Proposal:	Discharge of conditions 3 (materials), 4 (window/door details), 5 (rooflights), 6 (boundary treatment), 7 (passing places), 8 (landscaping), 9 (bats/birds), 10 (protected species), 14 (building record) of planning permission 3/2016/0216.
Location:	Little Dudlands Farm Rimington Lane Rimington BB7 4EA
Grid Ref:	380857 - 446573

The Highway Development Control Section has made the following comments regarding the discharge of condition 7 (passing places): -

4580 -00 C

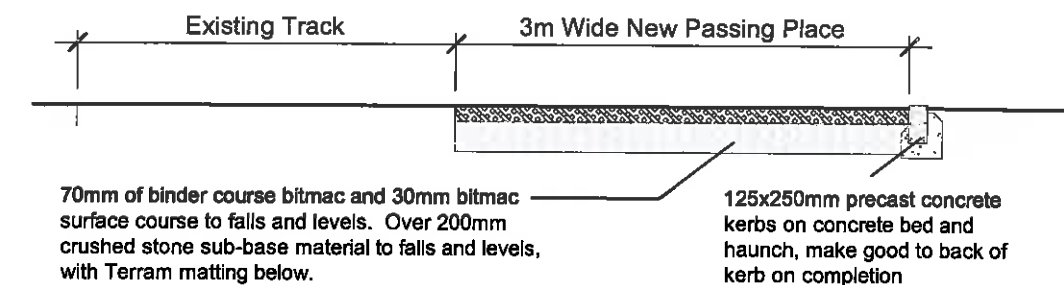
The location of the passing places is fully acceptable and are to be provided as shown on drawing 4580-00 rev C "Location Plans / Site Plan"

From an observation point only the proposed construction of the passing places is not to LCC standards and the applicant is advised to consider the long term maintenance issues especially where large farming vehicles are expected. The road is private and as such will not be maintained by LCC highways, the condition requires the passing places to be maintained for perpetuity.
